WEST SUSSEX COUNTY COUNCIL CONSULTATION

TO:	Arun District Council FAO: Mrs A Gardner
FROM:	Highways, WSCC
DATE:	31/08/2018
LOCATION:	Crossbush Farm Shop, Lyminster Road, Lyminster, West Sussex, BN17 7QN
SUBJECT:	LY/15/18/DOC Approval of details reserved by condition imposed under LY/28/17/PL relating to conditions 5- equipment to control odour/fumes, 9-secured & covered cycle parking & 11- closing of Calceto Lane for egress of vehicles.
DATE OF SITE VISIT:	n/a
RECOMMENDATION:	☒ Advice ☐ Objection ☐ Modification ☐ No Objection ☐ More Information ☐ Refusal
S106 CONTRIBUTION TOTAL:	n/a

Automatic Bollards

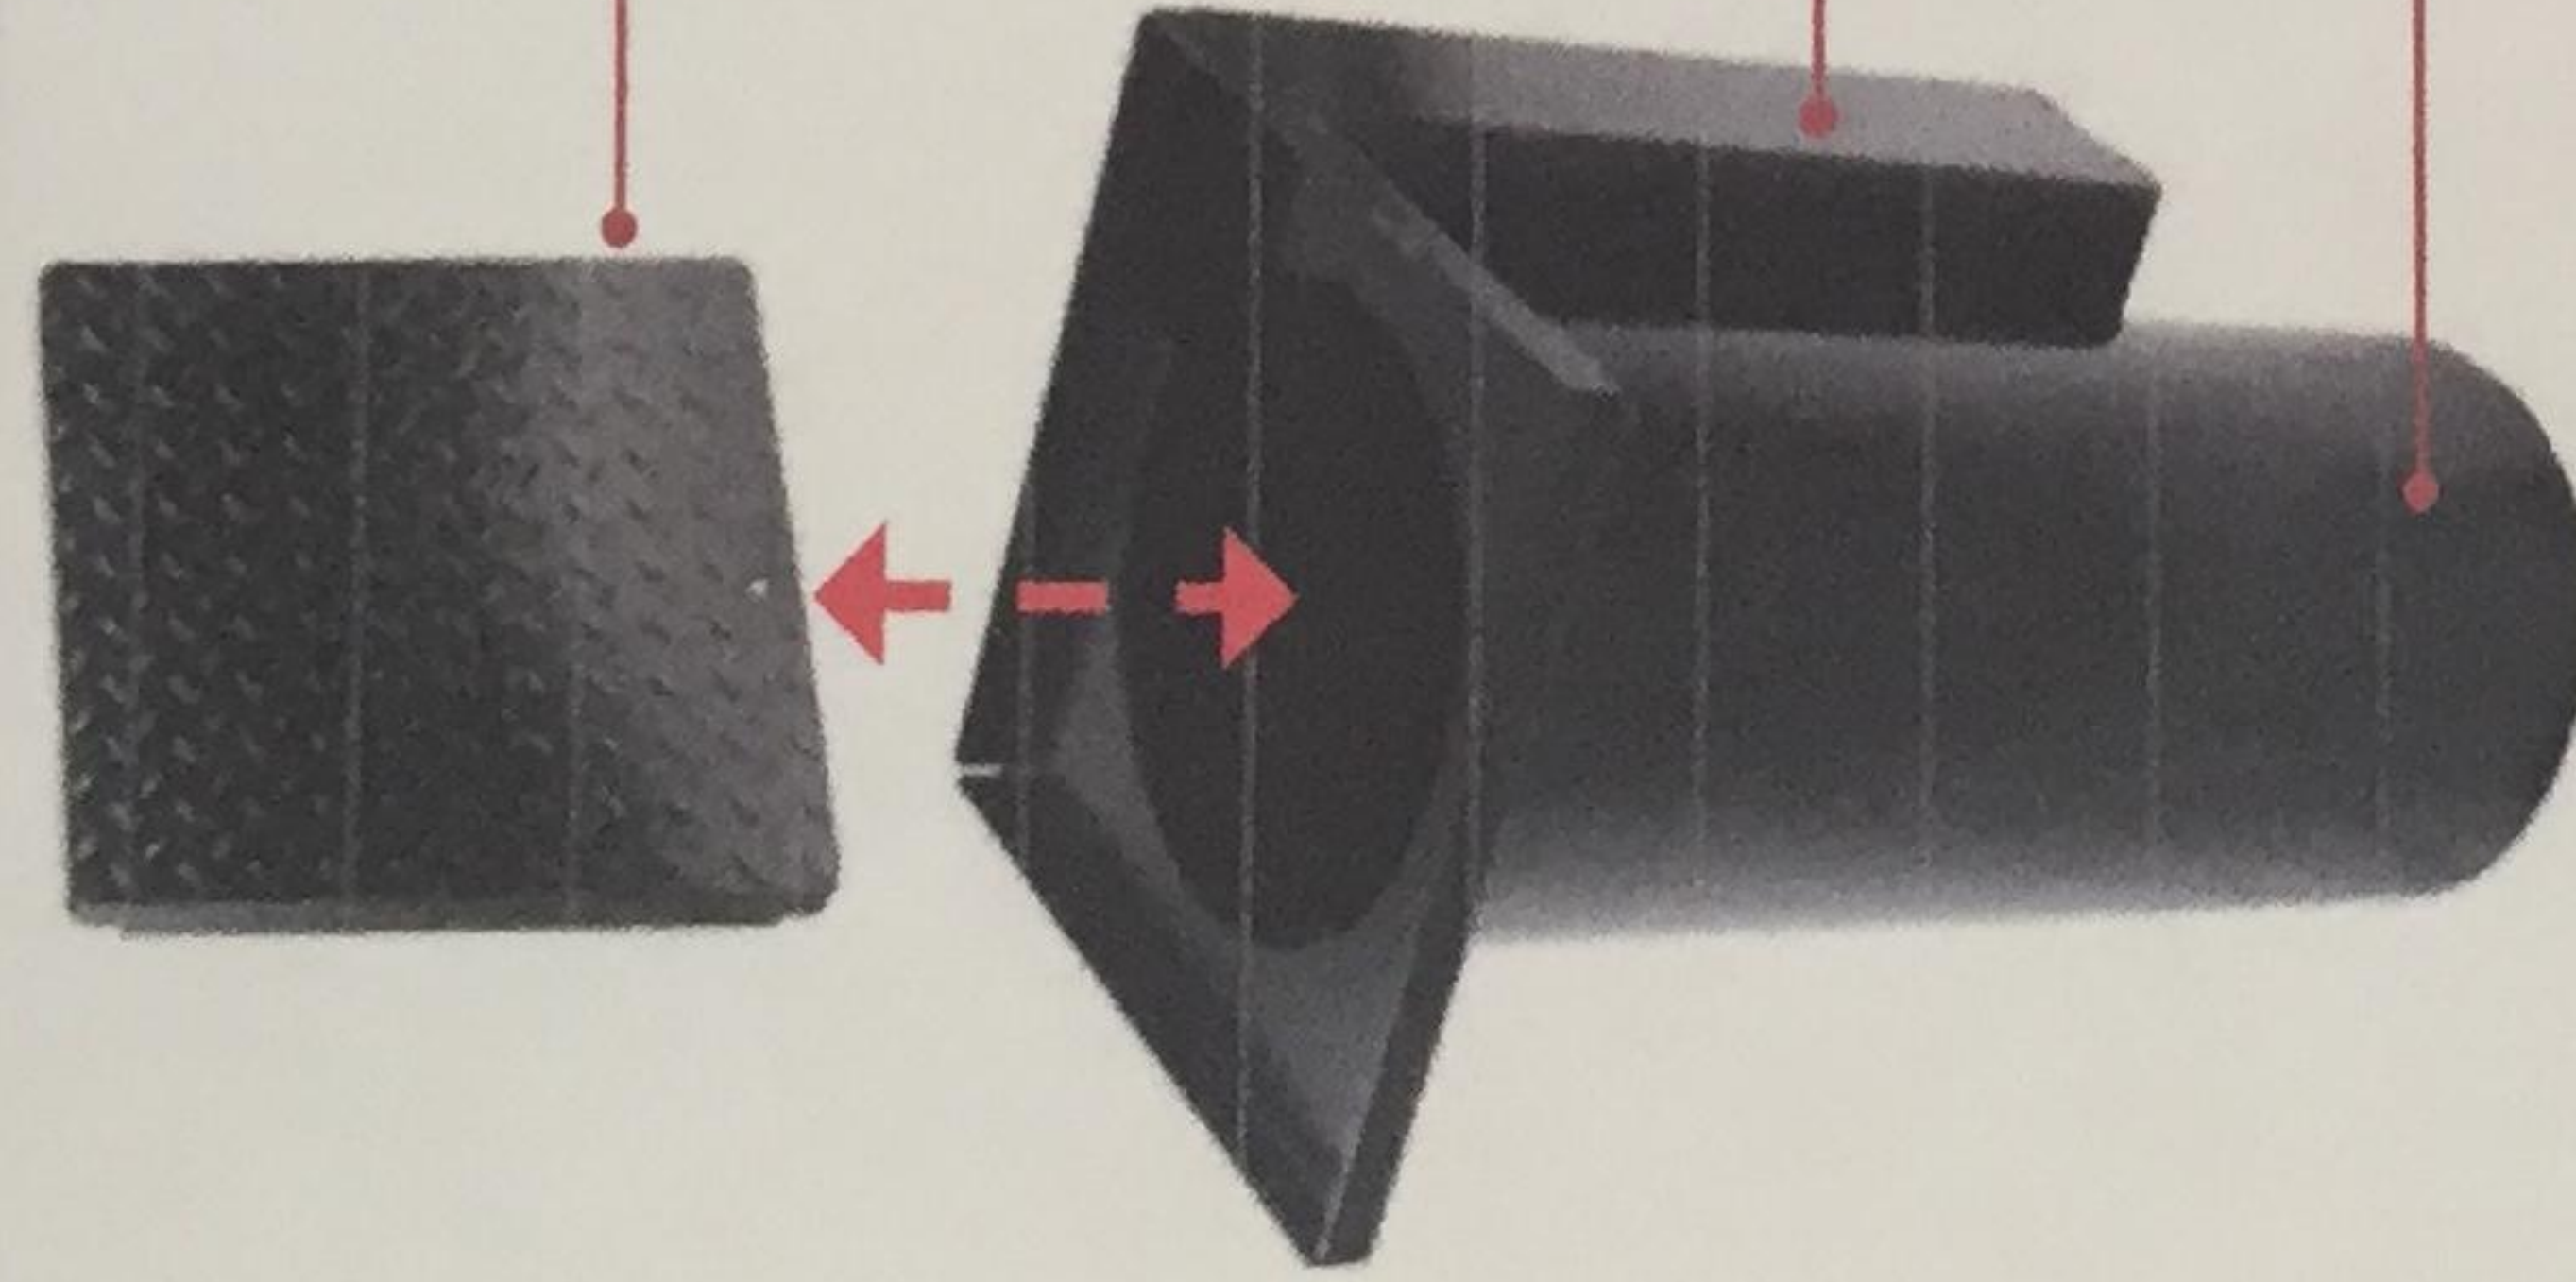
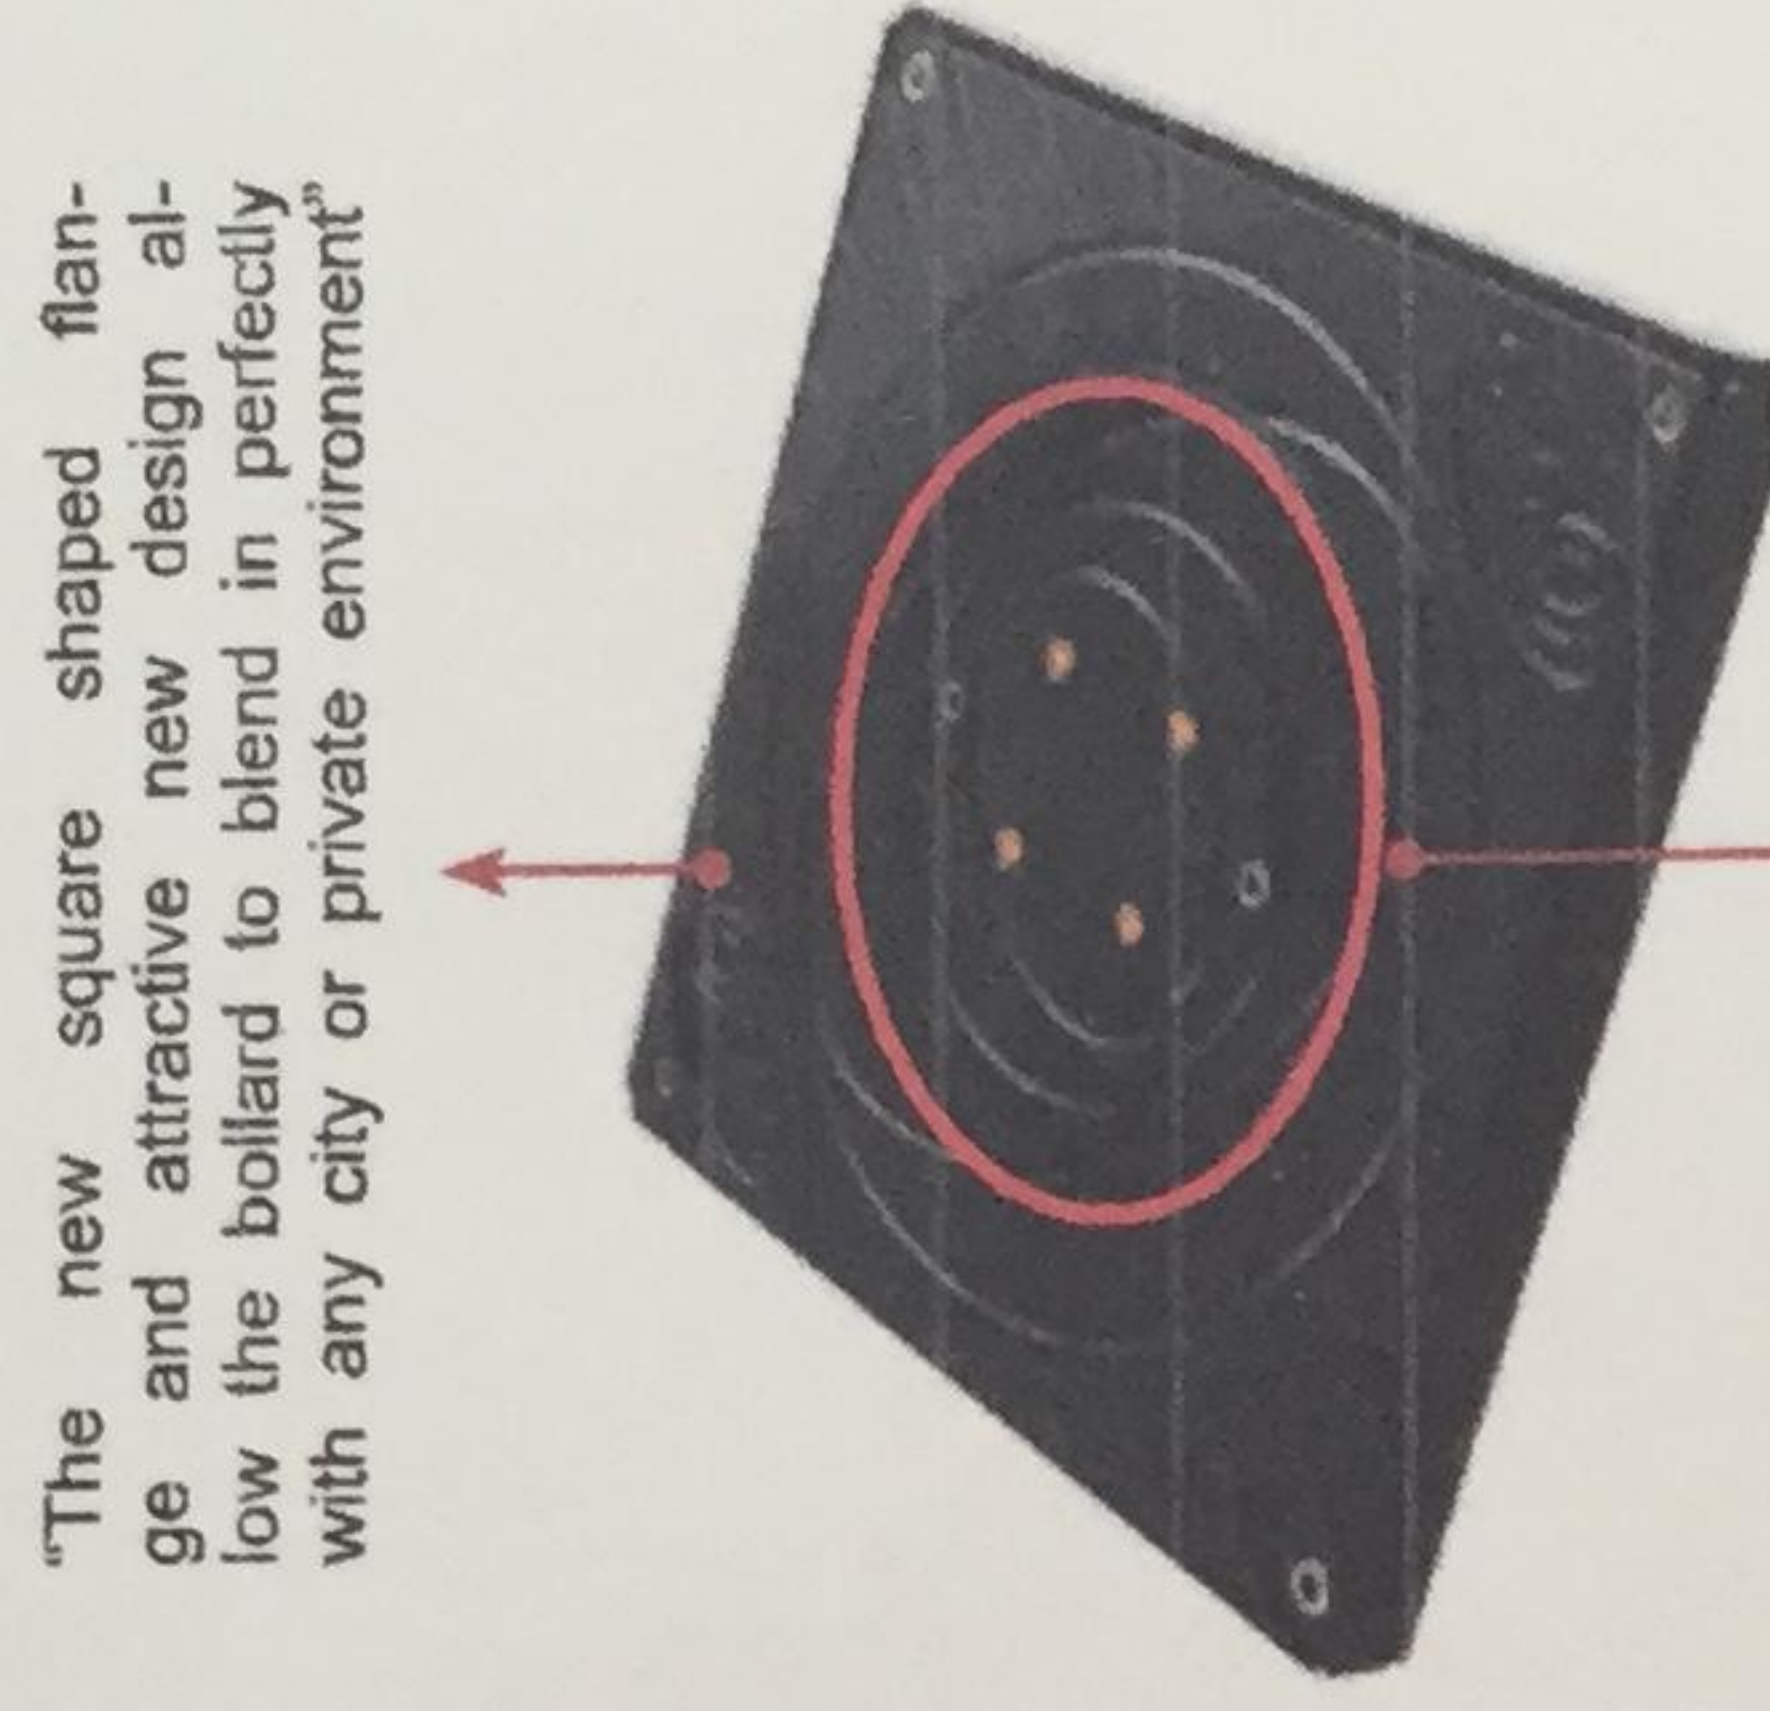
The applicant has submitted documentation detailing a raising bollard system that will be implemented to ensure ingress via Calceto Lane is achievable while restricting egress movements onto Lyminster Road.

I have consulted with WSCC Public Rights of Way and they are satisfied with the proposed.

The plans and details provided pertaining to this condition would be considered acceptable. If the Local Planning Authority are minded to grant approval I would ask an informative note is included requesting the applicant contact WSCC PROW [REDACTED] [REDACTED] after installation of the bollard.
